**MODIFICATION REQUEST:**

**61 Mobbs Lane, Epping (Former Channel 7 Site)**

**Amendment to Conditions A10 and E2 for  
Buildings 7 and 8 (MP 10\_0158 MOD 5)**

November 2012

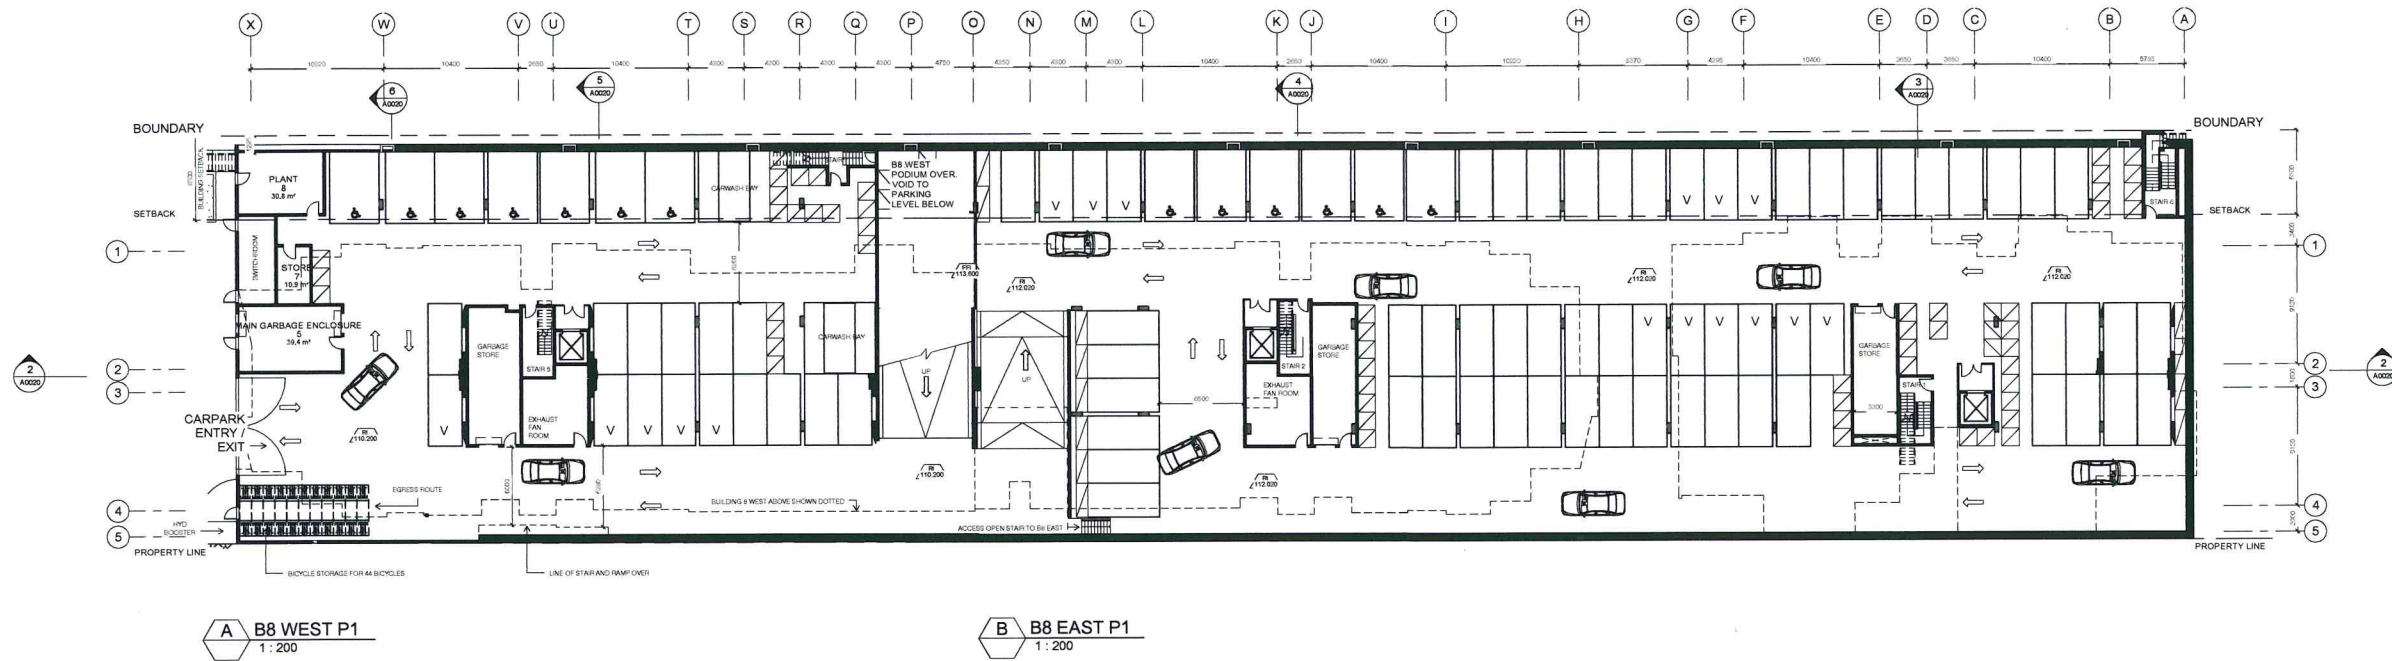
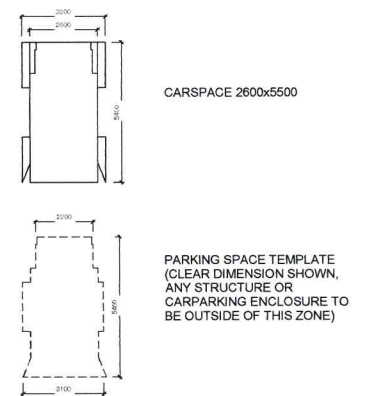
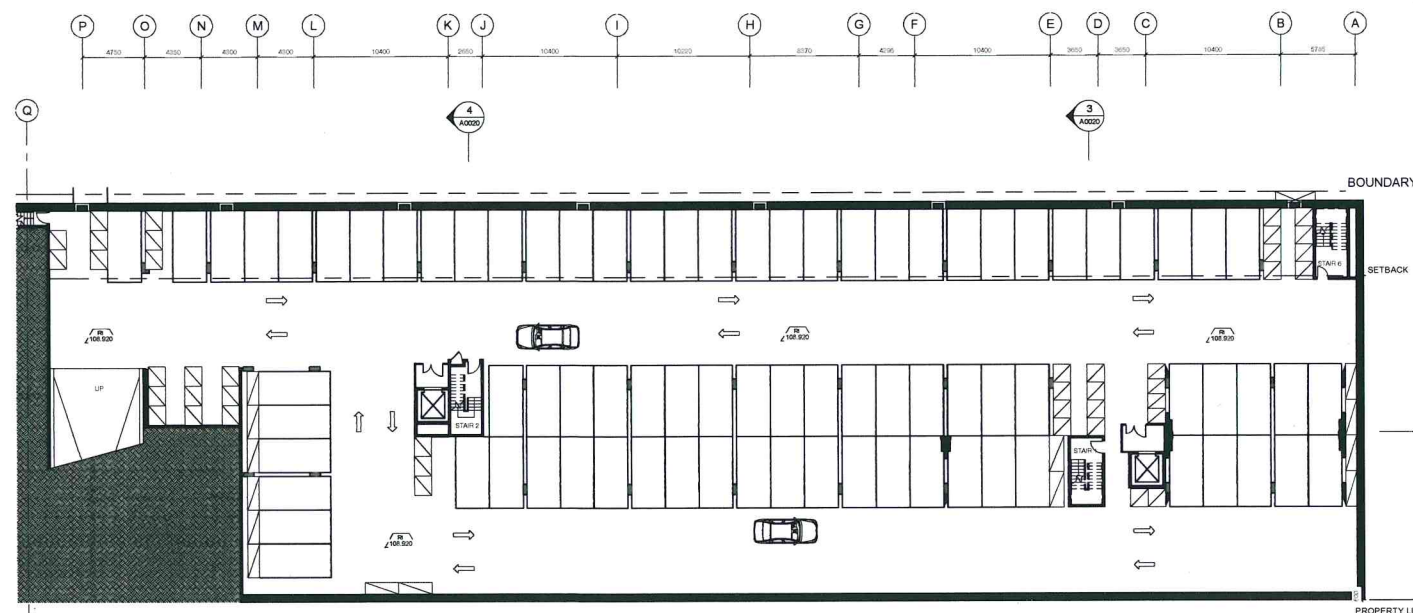
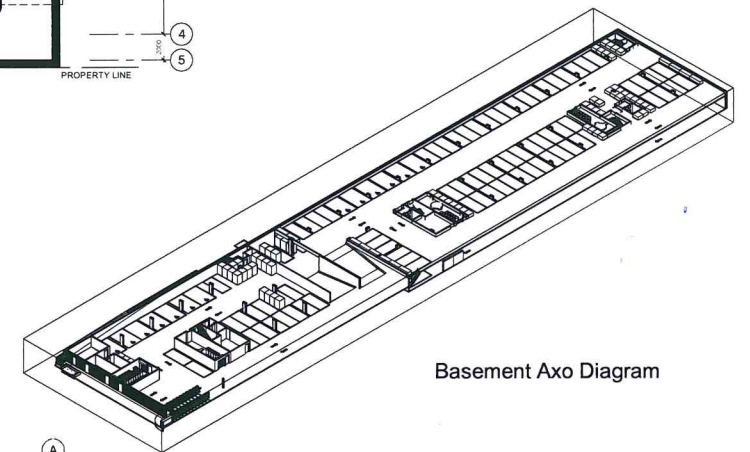
Meriton is now seeking approval of drawing number A0011A which disperses 17 visitor car parking spaces across both the Level 1 lower and level 1 upper car parks (see **Figure 4**).

The department has considered Meriton's preferred visitor car parking locations and is satisfied that it will allow for a more functional layout as visitors will be able to park in locations that are in close proximity to lifts for both Building 7 and 8. The approved location of visitor car parking is located near a lift to Building 8 only (see **Figure 3**) and the department considers that this will create confusion for visitors attempting to gain access to Building 7.

The revised location of visitor car parking will reduce safety issues associated with visitors attempting to walk within the basement and using the internal car ramp in order to change lifts to gain access to Building 7. In addition, the dispersed visitor car spaces will better cater for the long length of car park level 1.

- Update drawing A0011 of the schedule of approved drawings in Condition A2.
- Amend the first bullet point in Condition A10 by deleting reference to drawing A0011 dated 5 April 2011, and replacing it with drawing A0011A dated 25 October 2012.
- Amend the second bullet point in Condition A10 requiring the proponent to submit revised Strata Plans (Sheets 4, 5 and 6 of 23) that reflect the locations of the visitor parking spaces approved under drawing A0011A and denote all visitor parking spaces as common property.
